Recommendation Report for Works to Tree(s) on trees subject to a Tree Preservation Order (TPO)

REF NO: BN/109/21/T

LOCATION: Land adj to 26 Songthrush Lane
Barnham
PO22 0AE

PROPOSAL: Fell 1 No. Poplar tree (T7).

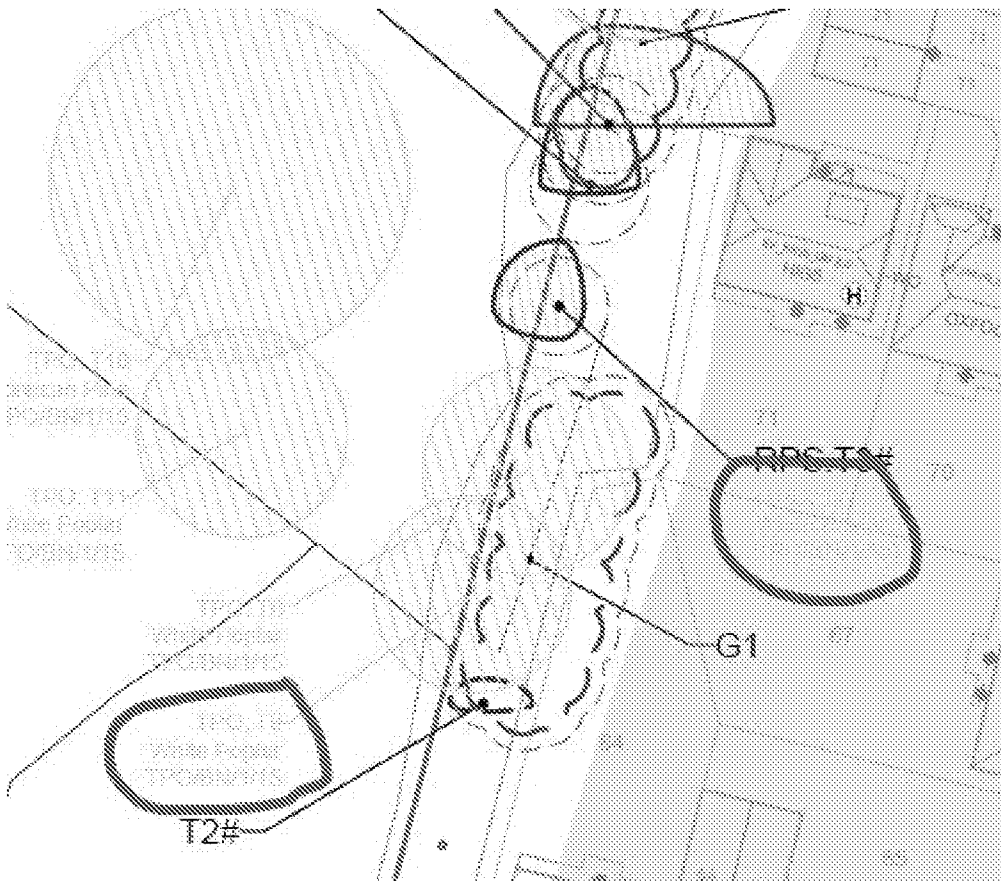
They are evenly spaced in linear formation. T7 has a single slender stem and I noted obvious large historic wounds at around 1/3 height. Those may have implications for long-term structural integrity.

T7 has undesirable form and structural integrity within the main stem could be compromised. Its removal may be necessary on health and safety grounds. A replacement tree of native species and standard form could be planted to the south of the established treeline and provide visual amenity as it matures.

T8 & T9 appear outwardly sound and no evidence of significant structural defect, disease or actionable nuisance has been provided in support of the application. As such, these trees should continue to provide significant landscape and amenity value, and ought to be retained.

I would like the applicant to be invited to agree to a revised proposal for lesser works (by removing items T8 & T9) as part of the current application so as not to incur further delay. Such work would go some way to addressing their concerns whilst preventing a diminution of the tree group's landscape and amenity value.

Once the tree has been felled (and either grubbed or ground out) then a replacement tree is to be planted adjacent the site boundary and alongside dwelling 26 Songthrusch Lane.

This is to be of Standard Nursery Stock proportions (10-12cm girth & 2m to 3m overall height) supported on a 'short stake' system with appropriate securing ties and pads.

It is to be planted within 12 months of the removal of the white poplar tree (T7).
